Re: Site Plan II Application Response to Comments  
Proposed Taco Bell, 1363 Washington Ave, Portland, ME

On behalf of the applicant, Guggenheim Retail Real Estate Partners, Inc., VHB has prepared the following responses to the review comments received from the Department of Public Works and Planning Department, dated February 11, 2016 and the Stormwater Peer Review, dated February 15, 2016 for the conversion of the existing Sala Thai restaurant to a Taco Bell facility. Please find the following materials included to accompany the responses:

Not Approved for Construction
Drawing Title
Layout & Materials

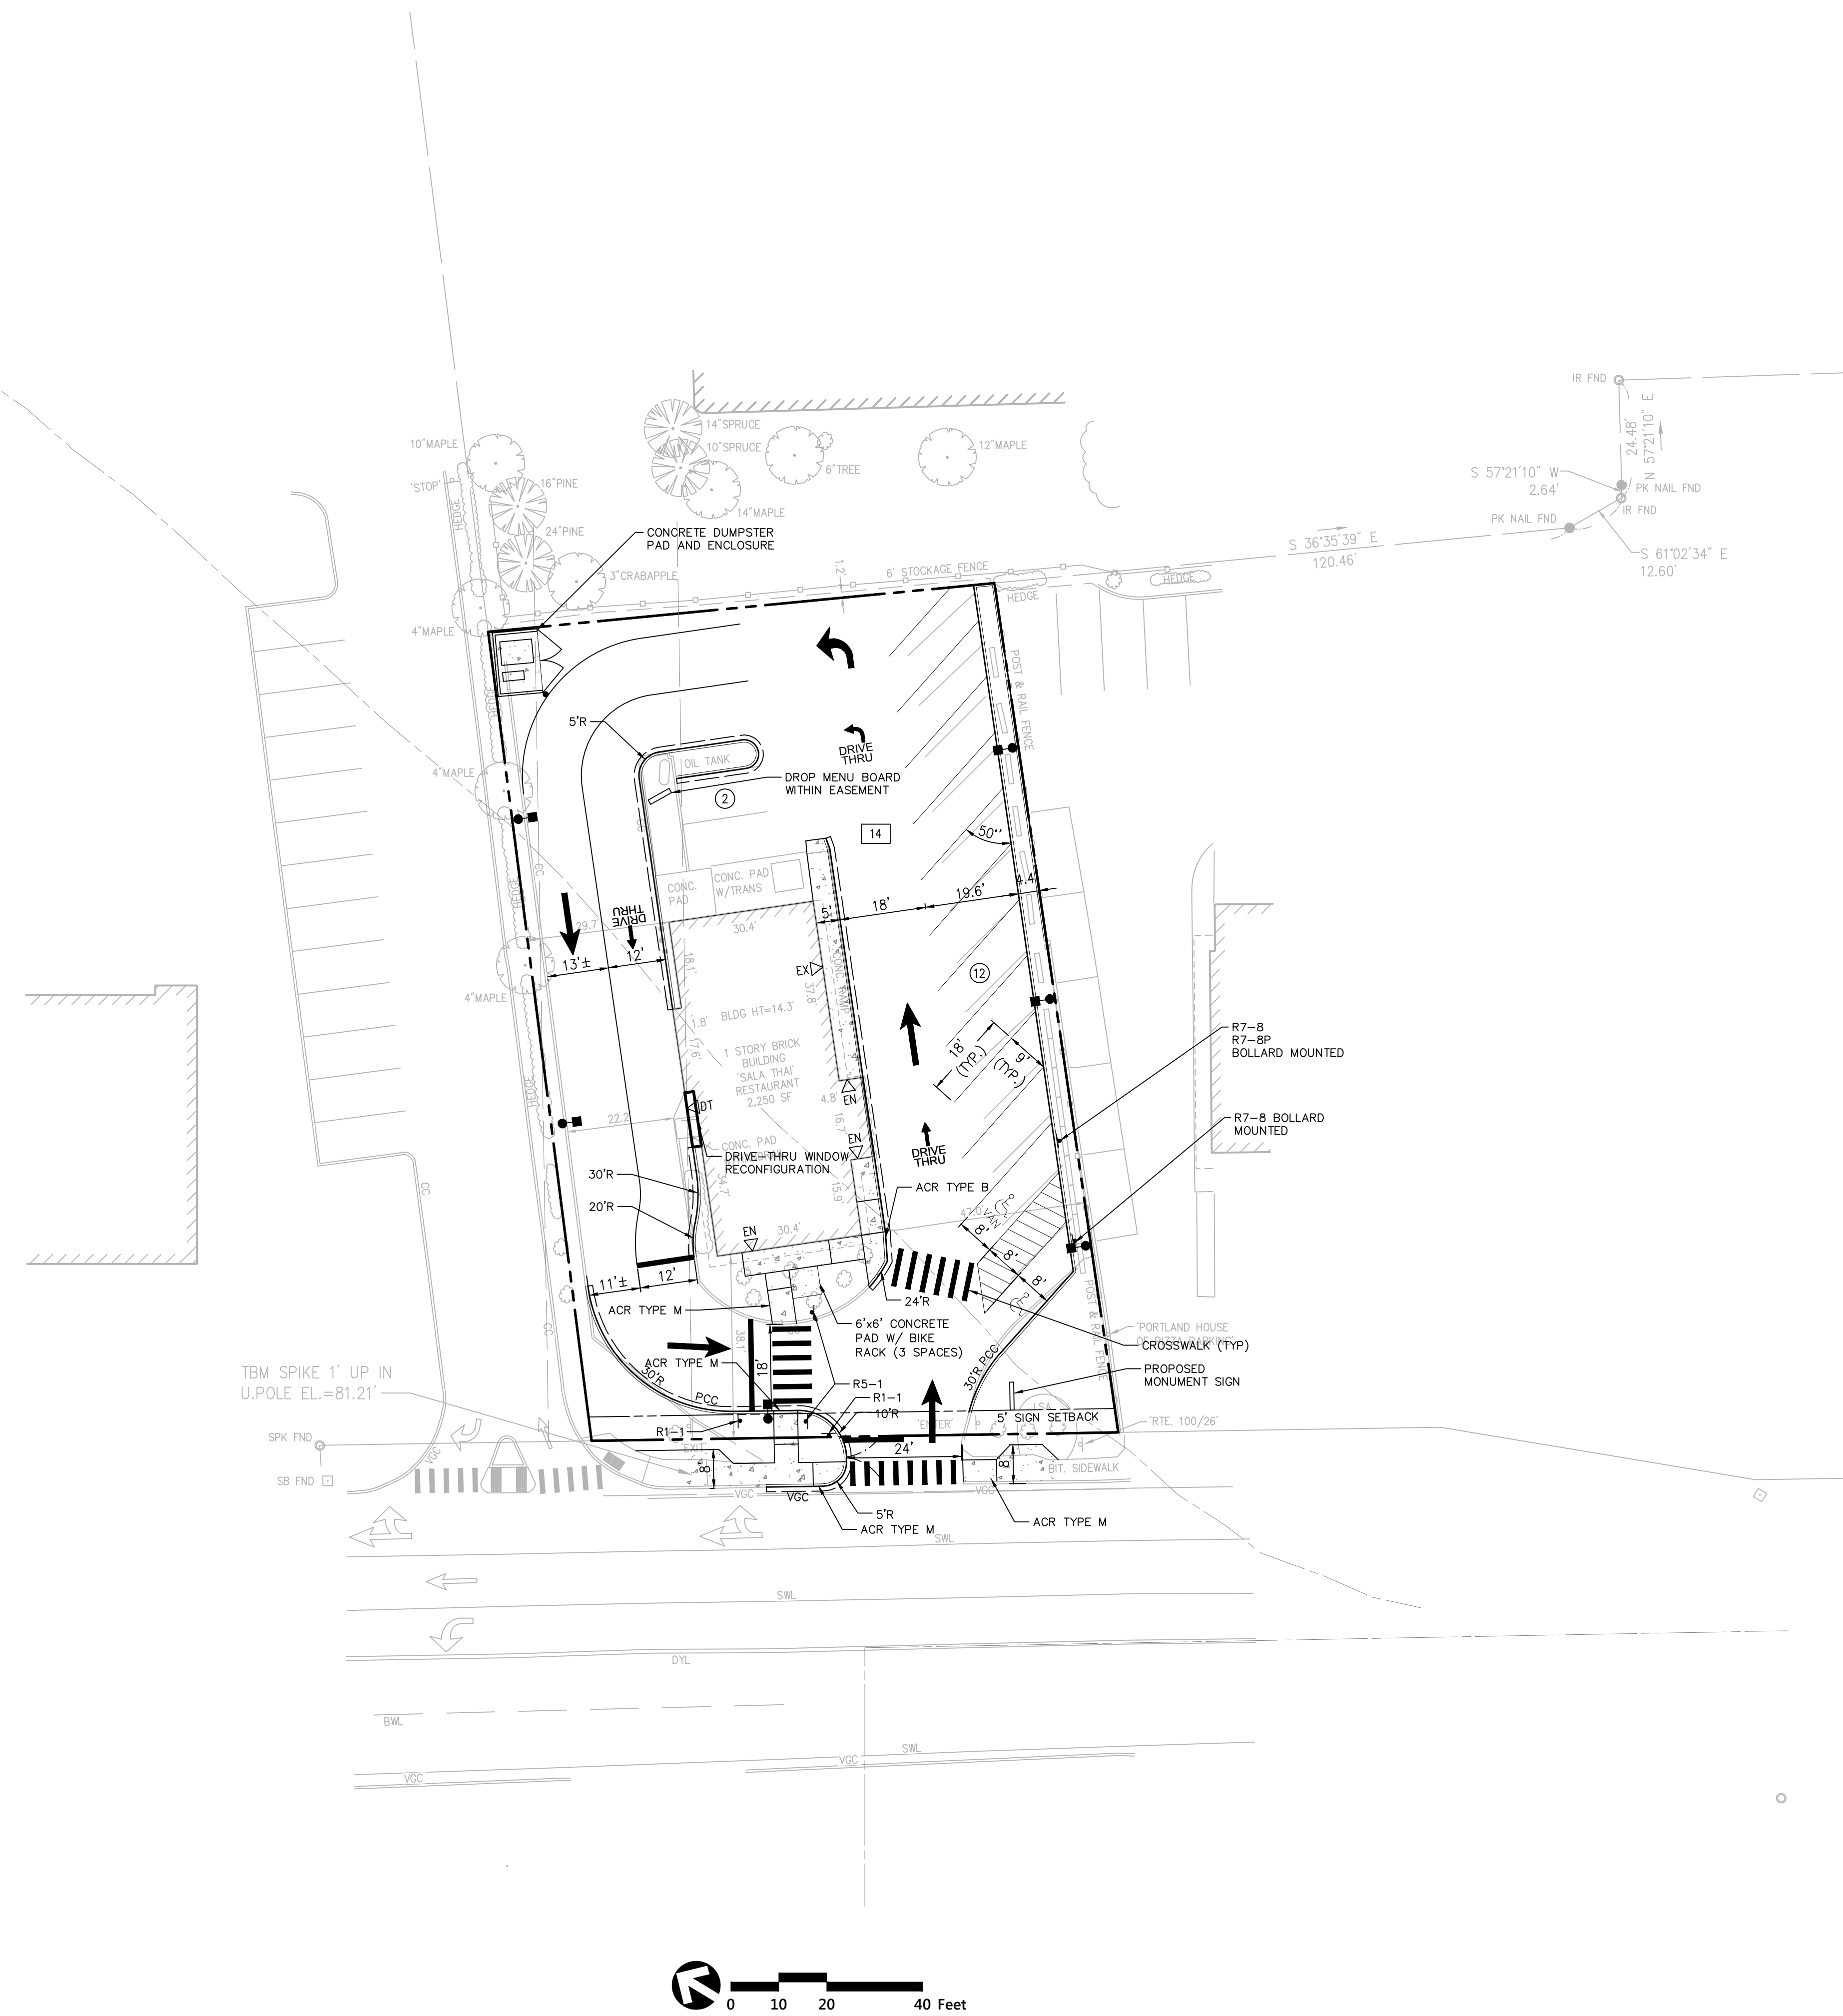
3. *Site Plan (C-2) - The proposed site improvements are challenging to follow as presented; the Site Plan does not include items typical of a Level II Site Plan submittal, including limits of work, spot grades, utility connection information and pavement repair limits.*

The Site Plan (C-2) has been modified to show layout and material aspects of the site work an additional sheet has been added to the plans to depict utility work only. No changes in grading are proposed for the site.

Not Approved for Construction
Drawing Title
Utility Plan
Drawing Number

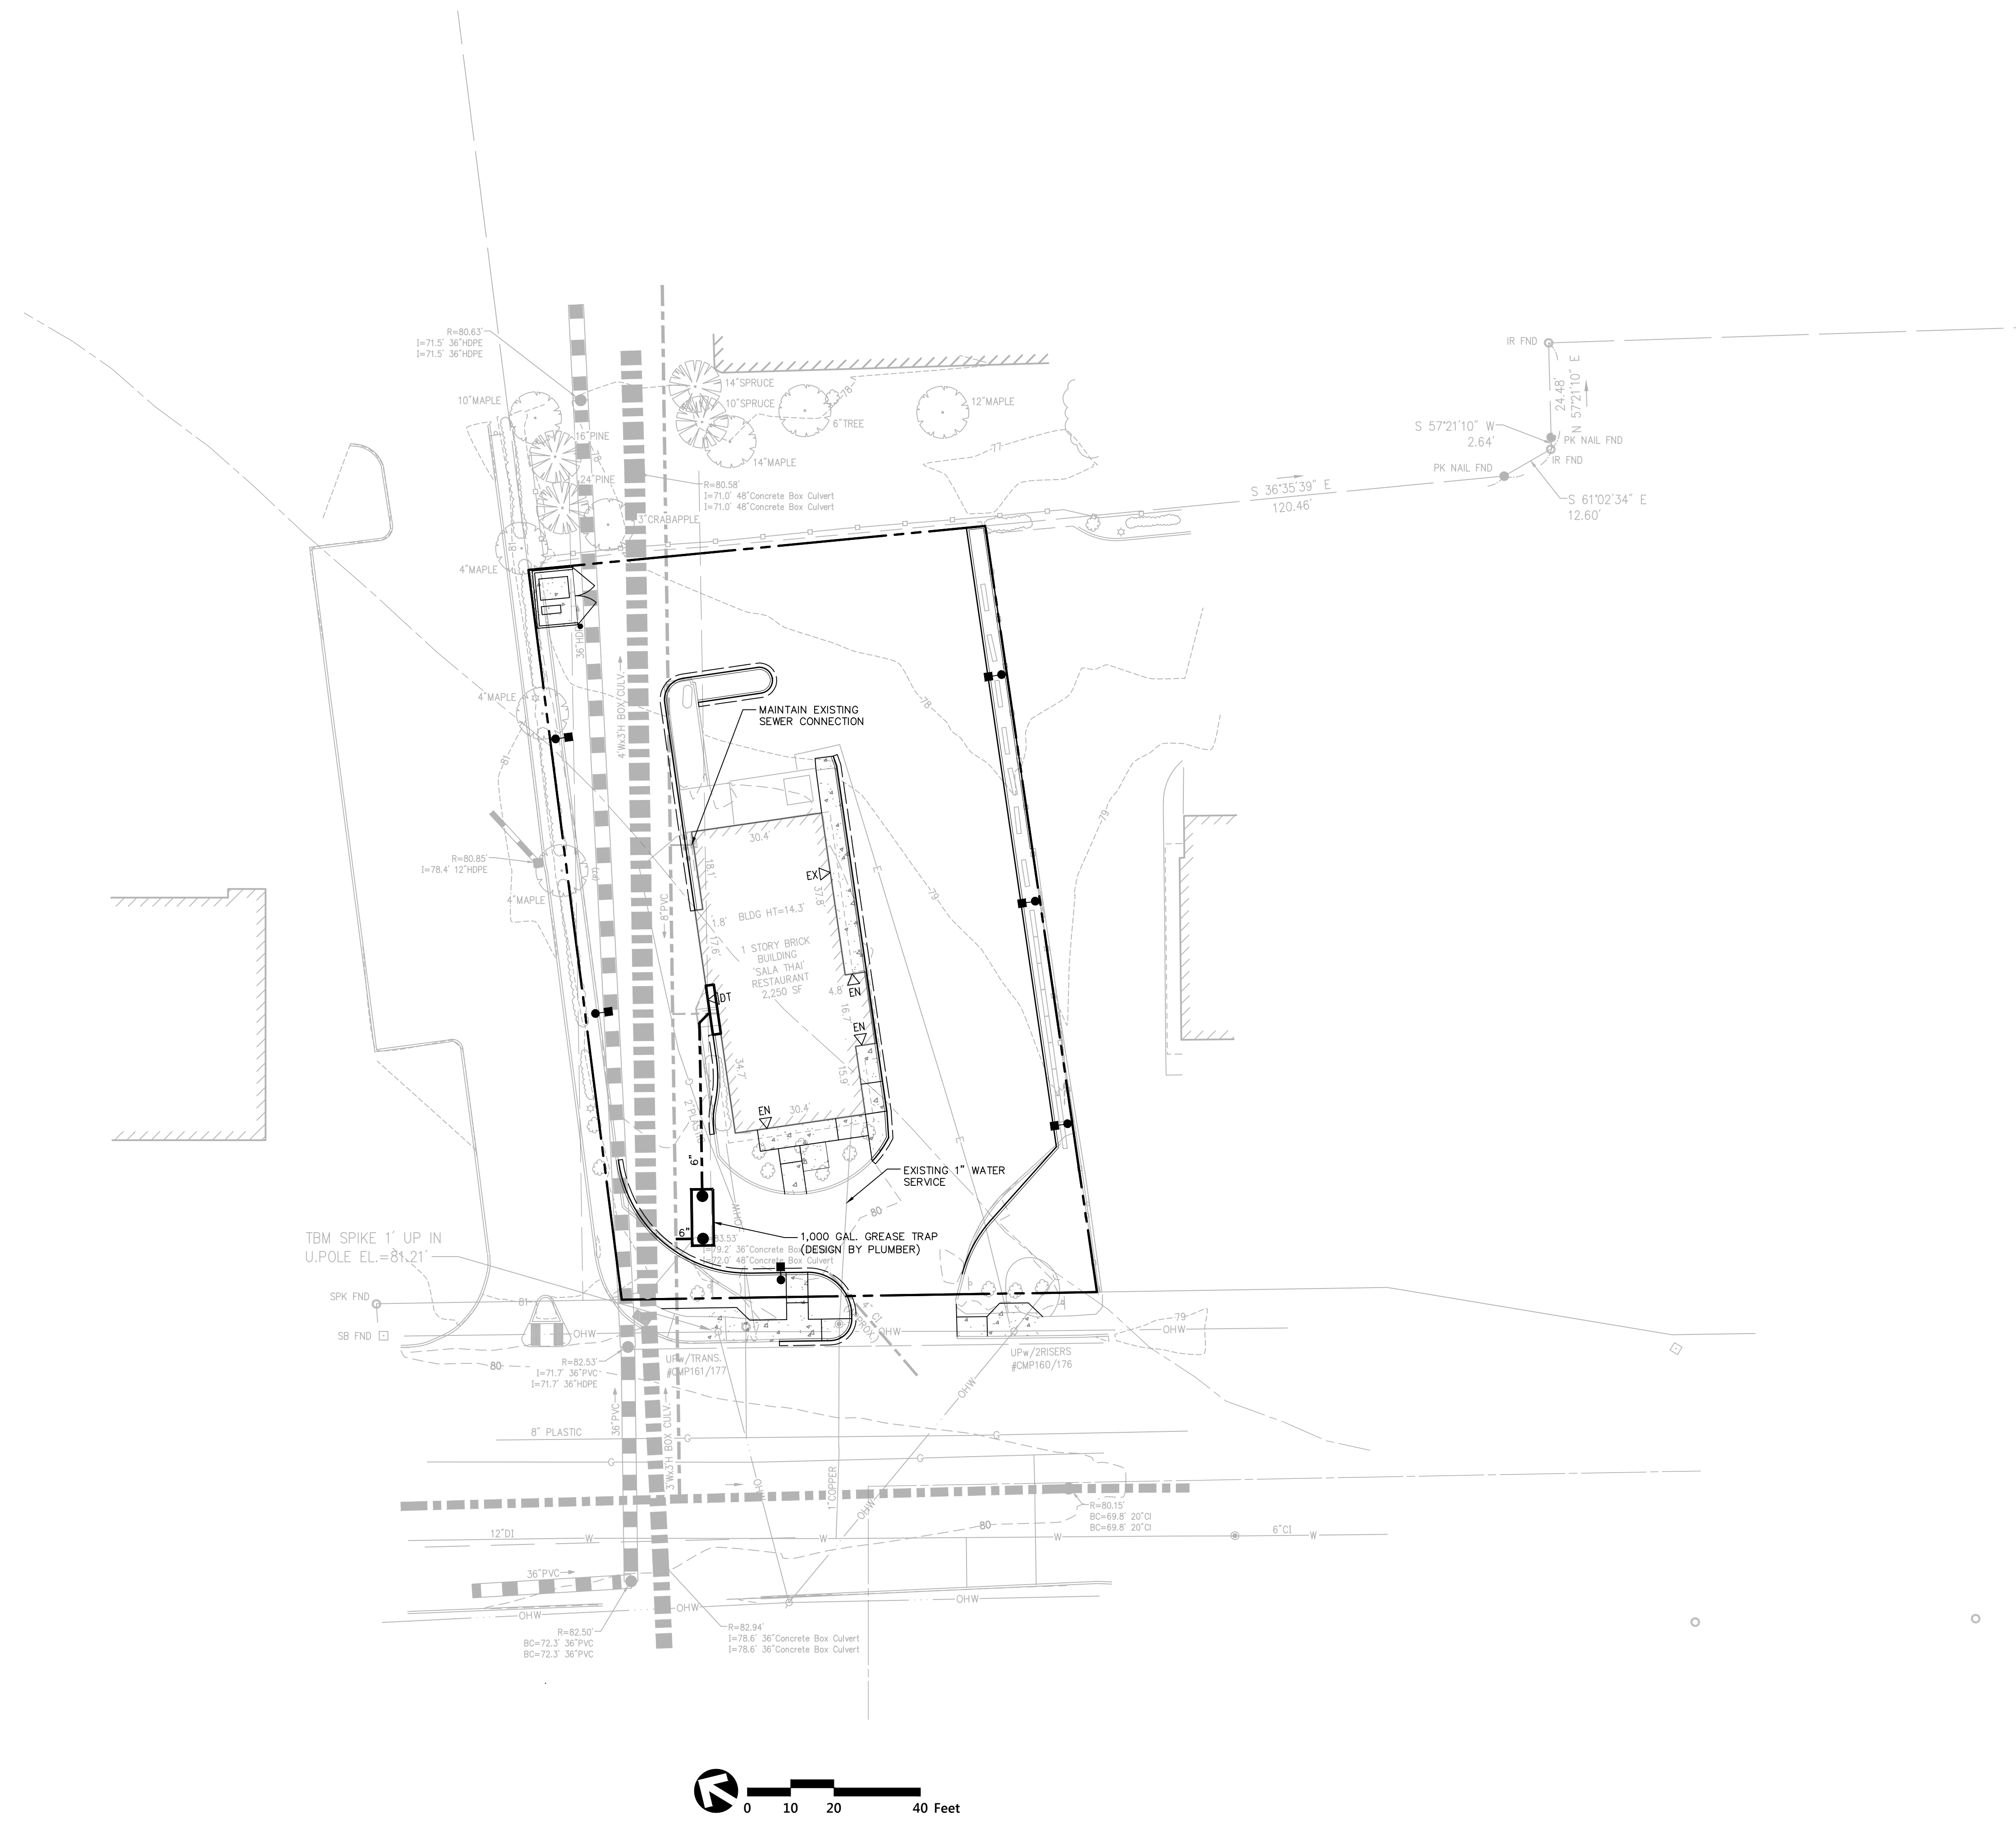
4. *The Existing Conditions Plan does not show an existing sanitary sewer service connection for the building. The Applicant has noted that a grease trap will be installed on the Site; however, it is unclear how it is intended to be connected to the City's Sanitary Sewer System. The existing 4" cast iron pipe is not shown to be connected to the building or the sewer main. The grease trap also appears to be located over a gas service. The Applicant should clarify.*

A separate Utility Plan has been made for the plan set to clarify utility connections.
